Current Zoning: TOD-TR (transit-oriented development – transition)  
 Proposed Zoning: CG(CD) (general commercial, conditional)

Approximately 0.776 acres located at the northeast intersection of South Boulevard and Starmount Cove Lane, east of England Street.

The petition proposes the development of a financial institution with accessory drive-through lane. The site is currently developed with a retail building.

RZ01 - REZONING PLAN

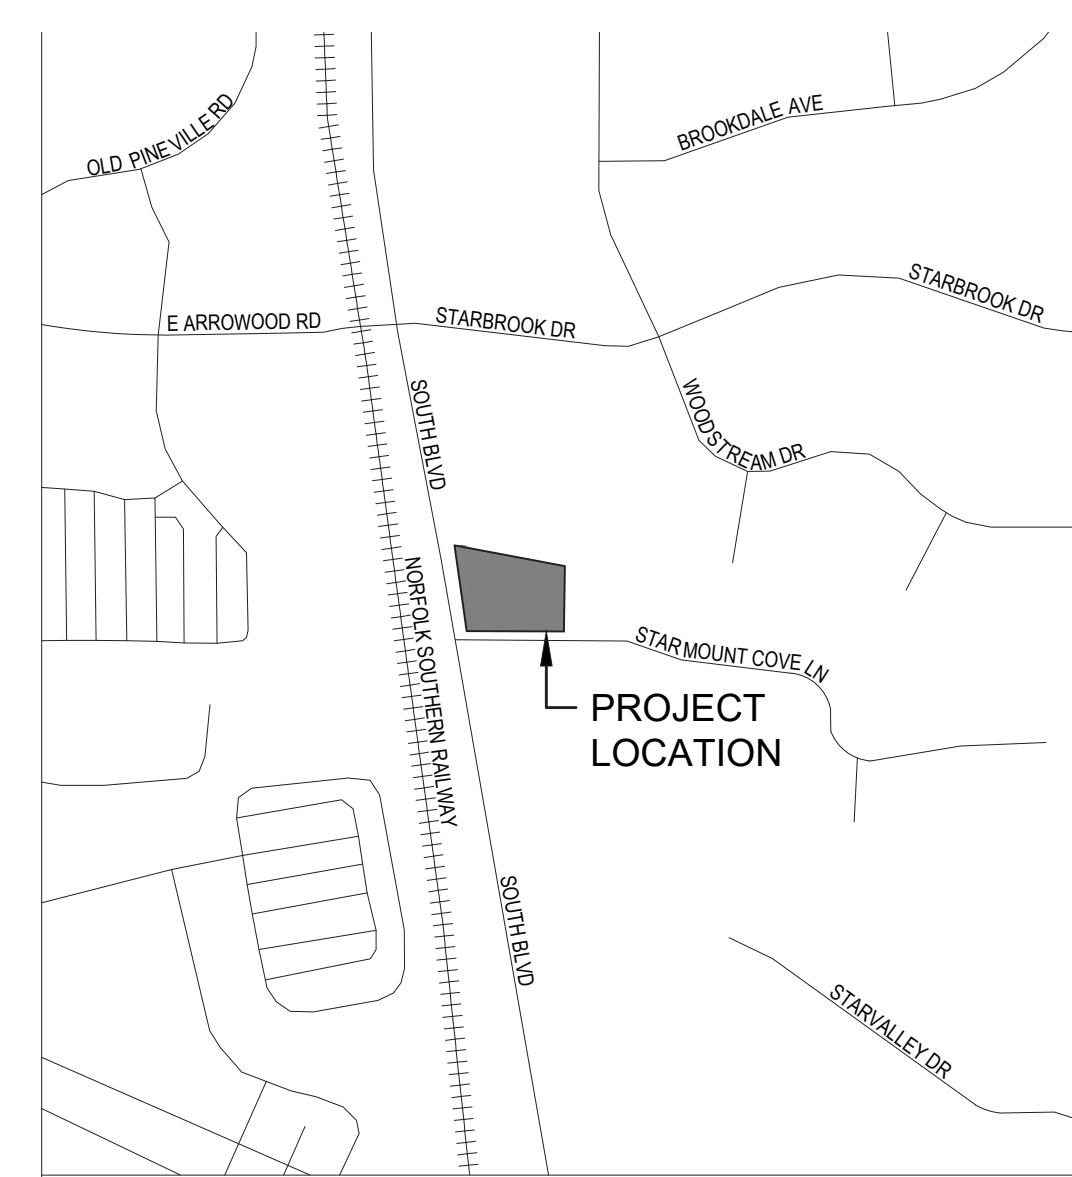
1. CDOT: Add a conditional note to commit to installing 8' sidewalk and an 8' planting strip along South Blvd and Starmount Cove Lane as shown on plans.
2. CDOT: Please clarify on plans if the existing curb is remaining or if it is being relocated to future back of curb. Curb relocation is not required, but the sidewalk and planting strip should continue to be shown based on future curb location.
3. CATS: A bus stop will be required at site. Adjacent bus stops will be consolidated into new shelter pad 60.03C. The final location will be coordinated in Land Development.

4. Reorient the building to front on South Blvd and Starmount Cove Ln and push the parking and drive-through facilities fully to the side and rear of the building.
5. Meet all applicable prescribed conditions for accessory drive-throughs located in Activity Center Place Types rather than Commercial Place Types to better align with the 2040 Policy Map.
6. Remove parking and maneuvering areas from between the building and frontage. This allows the setback requirement to be reduced to CAC-1 standards.
7. Remove the driveway access to South Blvd to enhance pedestrian facilities.
8. Add architectural standards to the plan that comply with the TOD-TR zoning district and the Community Activity Center Place Type.

9. Calculations of parking provided are incorrect. 8 parking spaces shown on plan, data table states 11 are provided.
